Recommendation Report for Planning Permission for Works or Extension to a Dwelling

REF NO: R/207/20/HH

LOCATION: 44 Shaftesbury Road
Rustington
BN16 2HX

PROPOSAL: Conversion of garage to habitable use and single storey rear extension

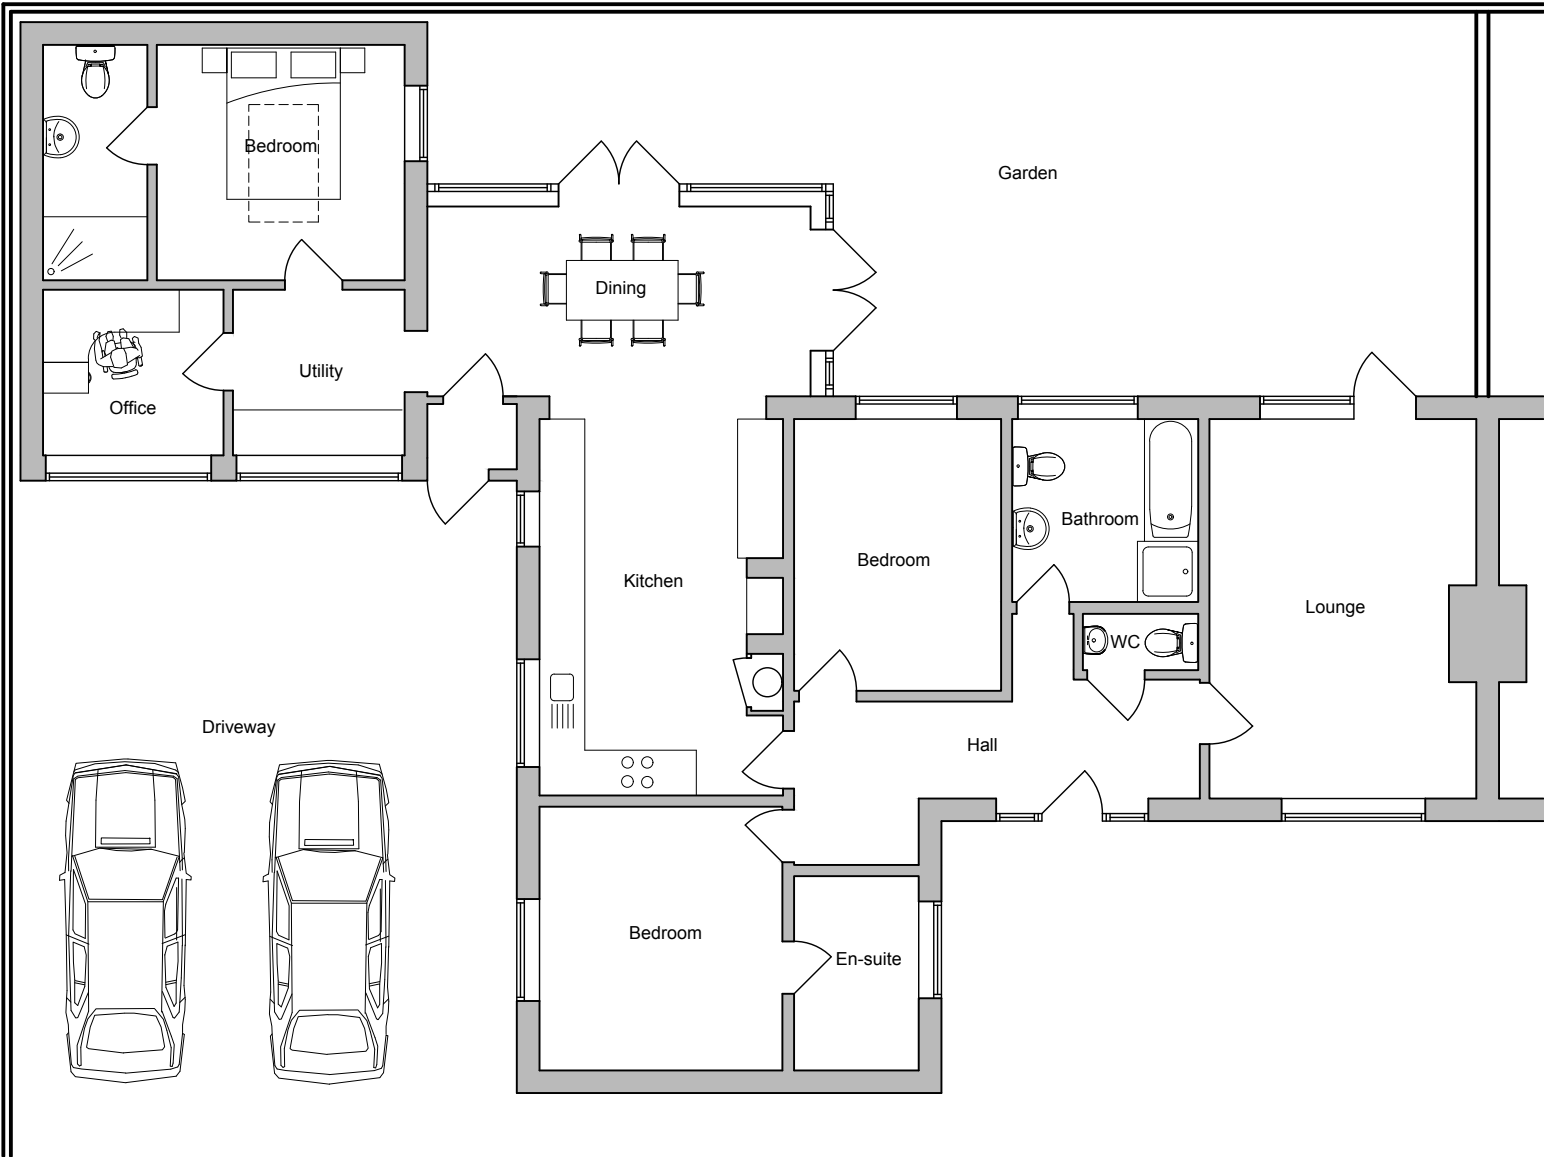
The proposed rear extension will be located 2.5m from the northern boundary and 8.5m from the eastern boundary. On the rear elevation there is one set of French Doors. On the front elevation there will be 2 No. windows. The proposal also includes 1 'Velux' window in the roof of the current garage, this, due to location, is not considered to overlook due to the location and angle of views.

Whilst the conversion of the garage will lead to a loss of a parking space there is sufficient space to the front of the property for vehicles and as such the alteration is not considered to give rise to any adverse parking or highway issues.

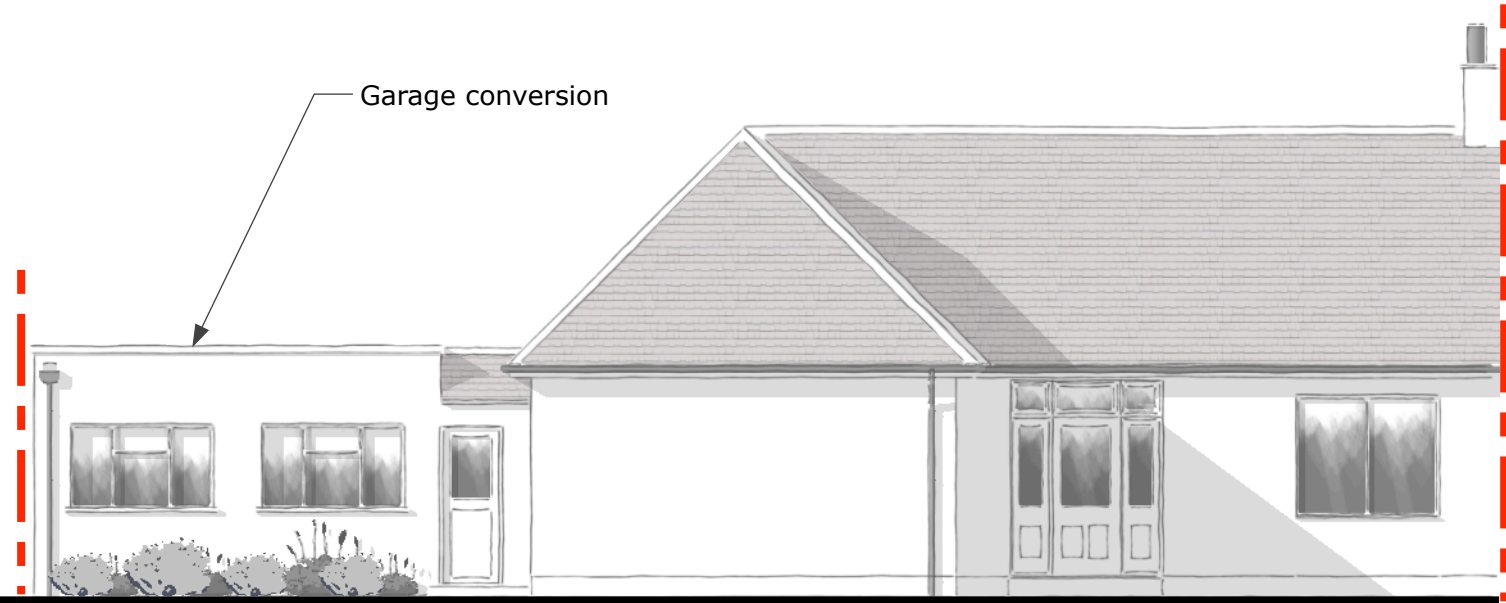
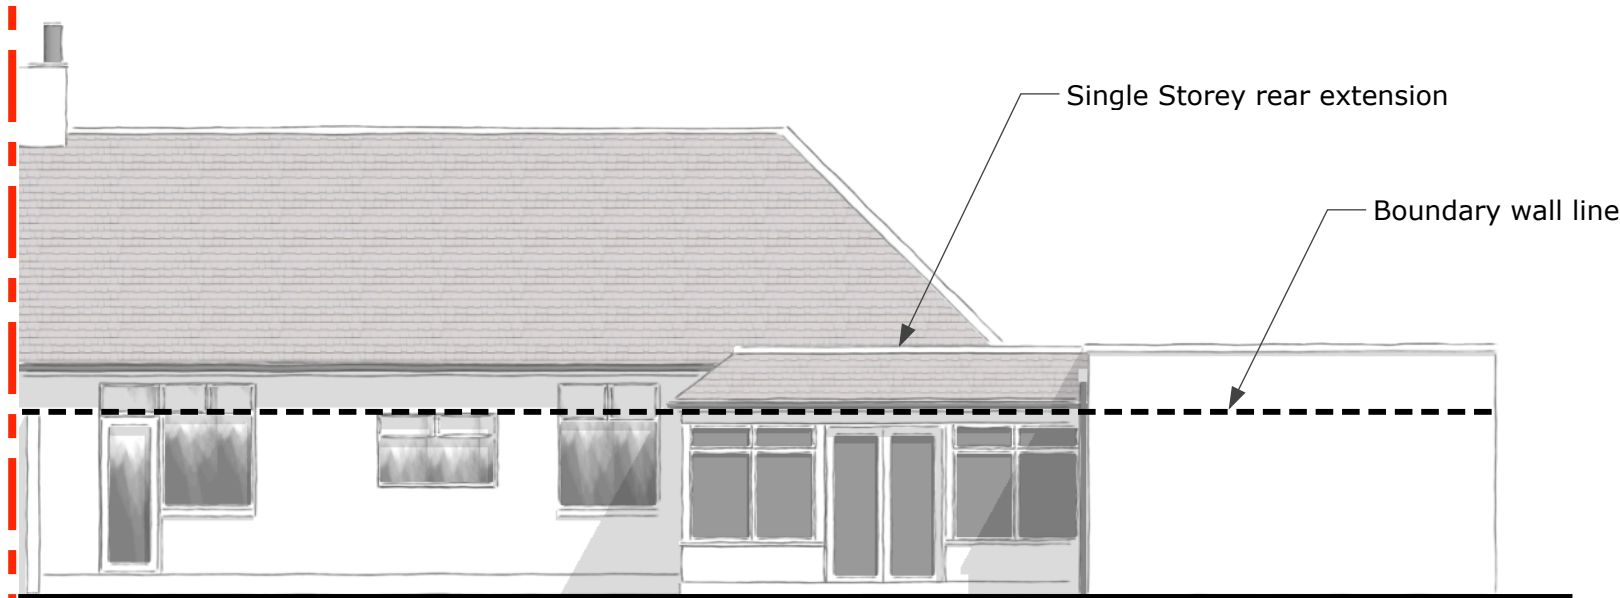
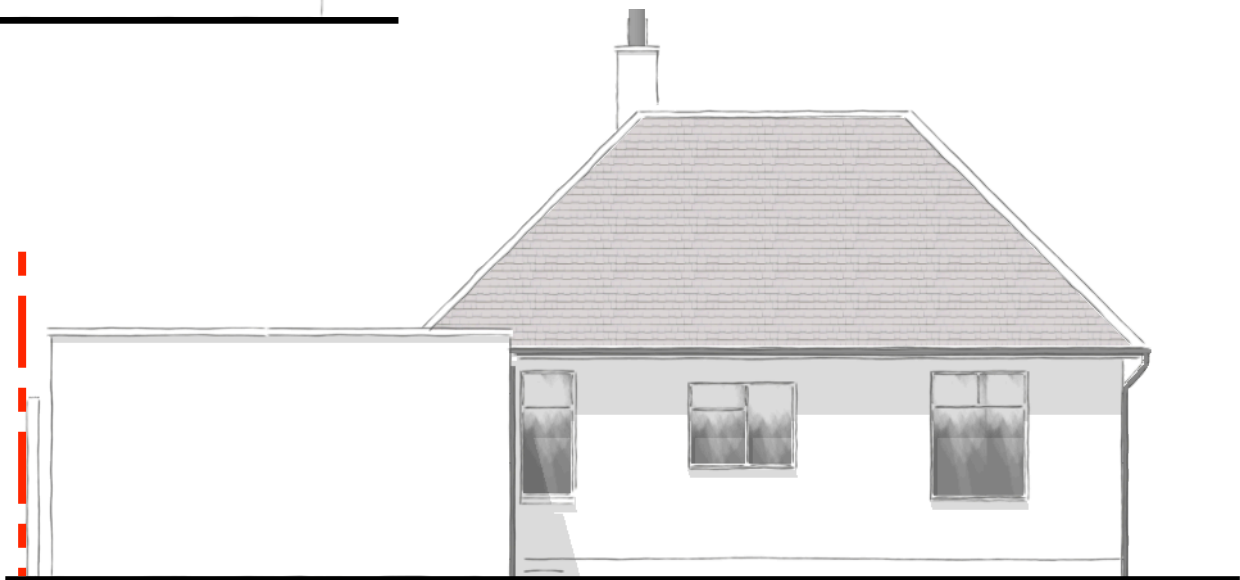
The applicant seeks planning permission for the construction of a rear extension to the established garage. The proposed rear extension will measure approximately 5.4m wide, 3m in depth and be built to the proposed height at top of pitch 3.2m and eaves measuring 2.5m.

The proposed conversion of the garage given its location will be visible from the street scene however, the proposed rear extension will not be visible from the street scene. It is not considered to have a detrimental impact on the character of the host dwelling or the street scene.
